Application for Removal or Variation of a Condition following Grant of Planning Permission or Listed Building Consent

Retrospective application for extensions to side and rear and first floor (an increase of 300mm to east elevation compared to previously approved applications 3/2021/0428 and 3/2021/1074) and the insertion of an additional window at ground floor on the eastern elevation. Obscure glass to sides of roof terrace and balcony as per existing approval. External stairs proposed to be re-positioned to rear (previously positioned on the East side).

Application 3/2023/0118

Condition 1 should relate to the updated drawings: 6219 P01J Proposed Elevations, 6219 P02J Proposed Floor Plans, 6219 P03I Proposed Site Plan. (All other referenced drawings to remain as current approval ref).

6219 - P01J

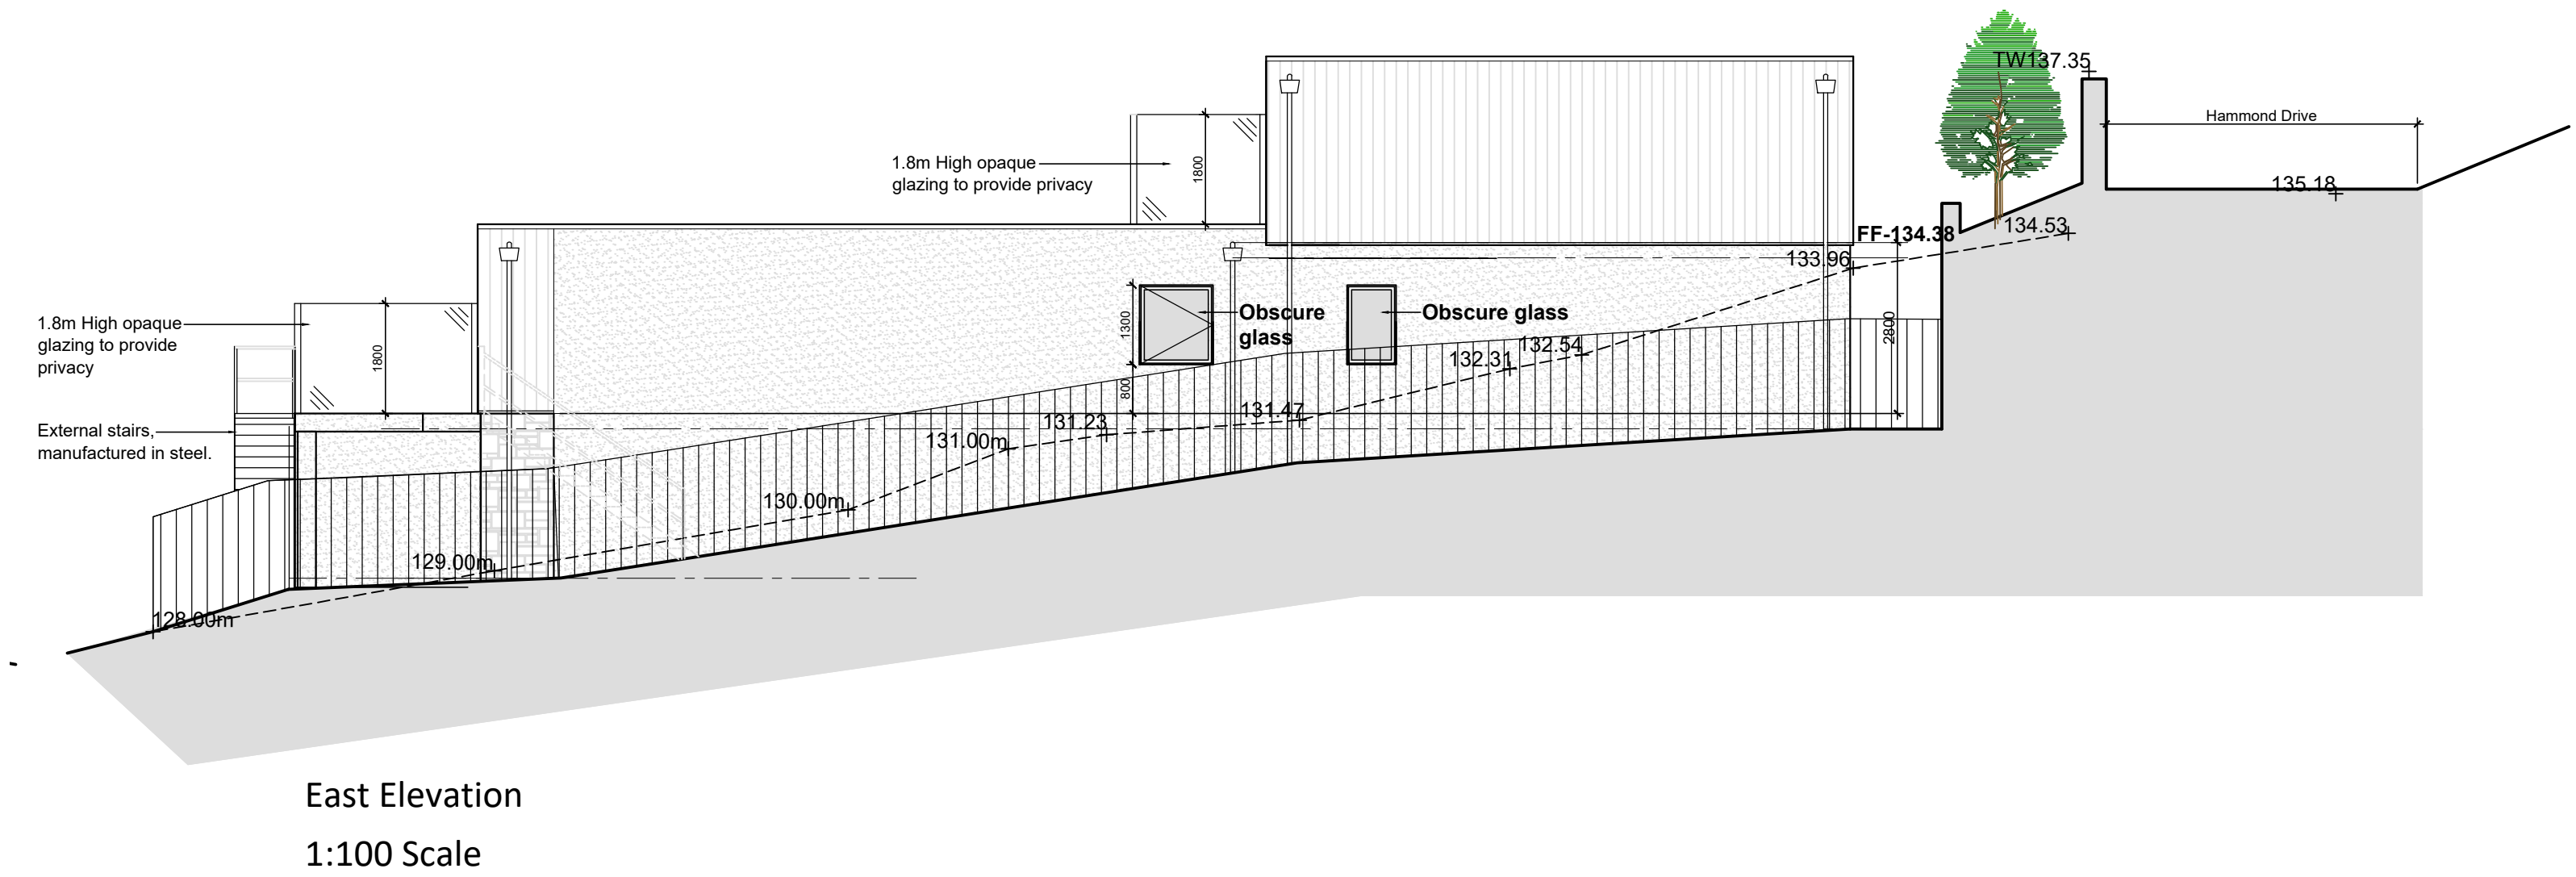
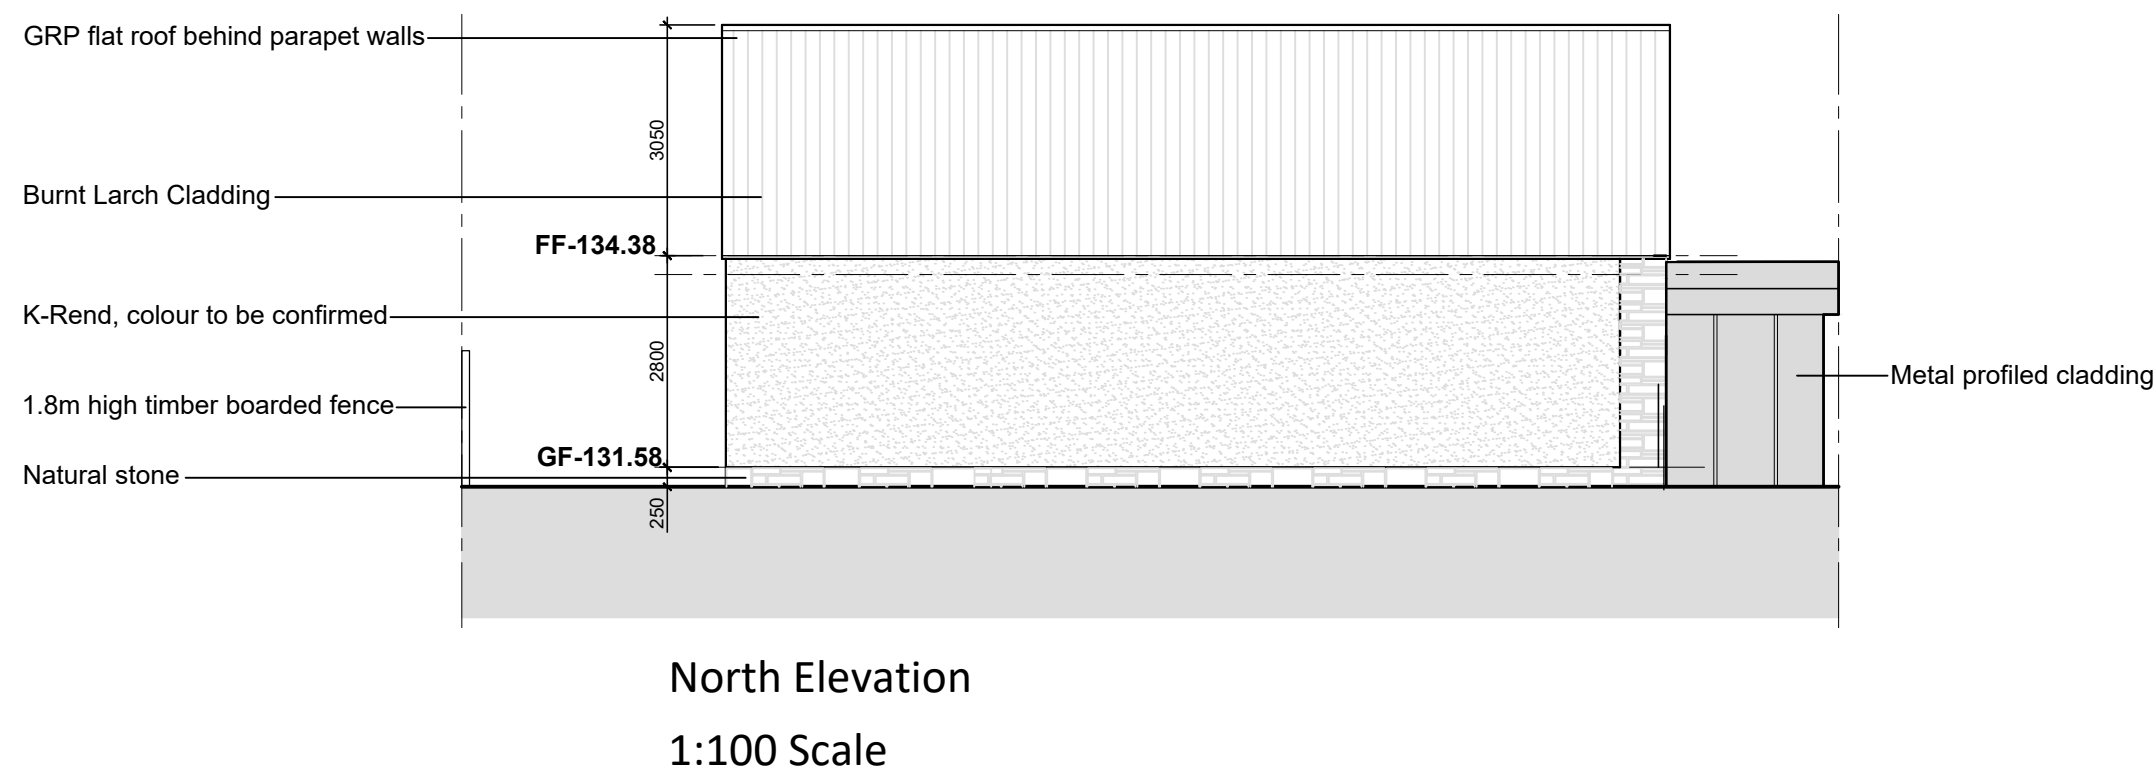
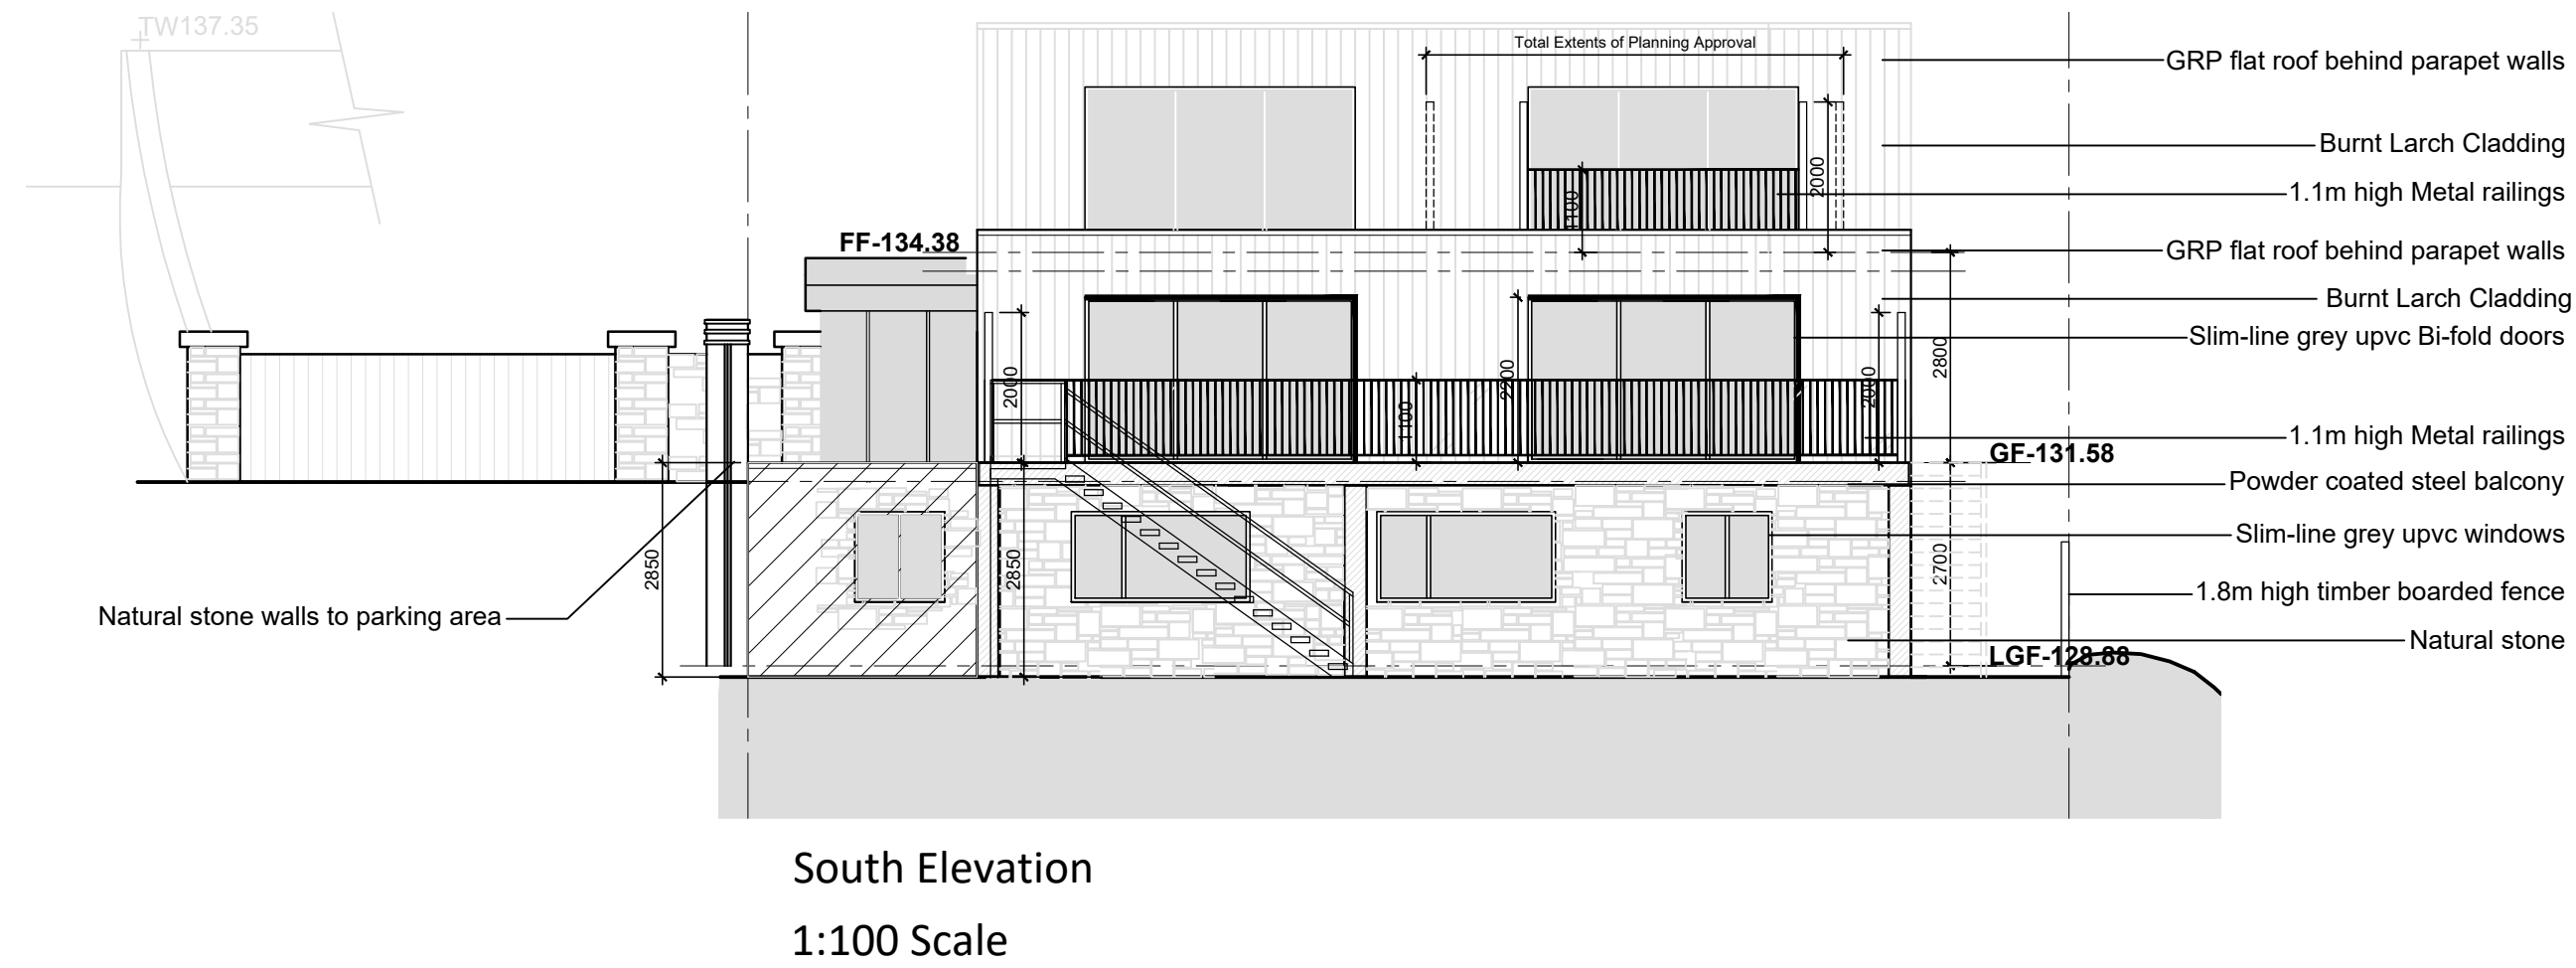
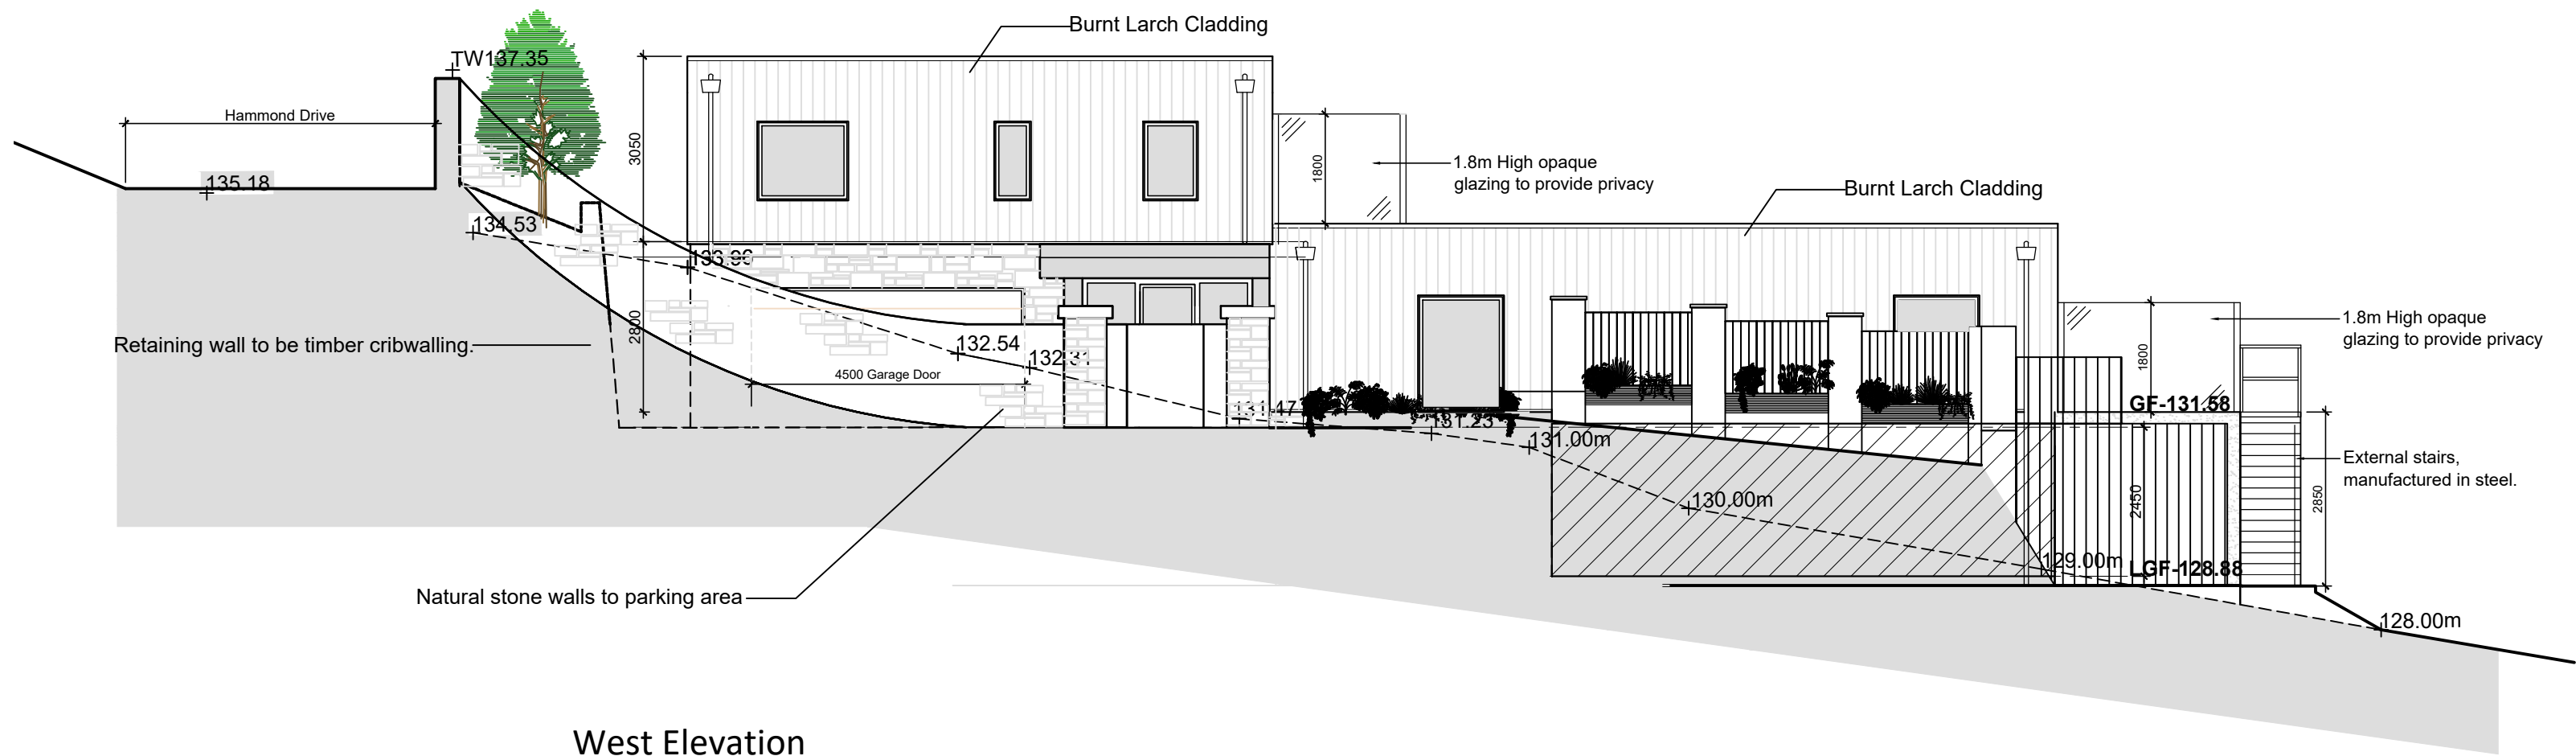
Drawing references to be updated to as built / in progress drawings following review on site. Privacy glazing reinstated with 1.1m metal railings towards rear garden. Minor amendments to window sizes and openers. External staircase repositioned on the rear (previously on the East side). All updated on Proposed Floor Plan and Proposed Elevation drawings.
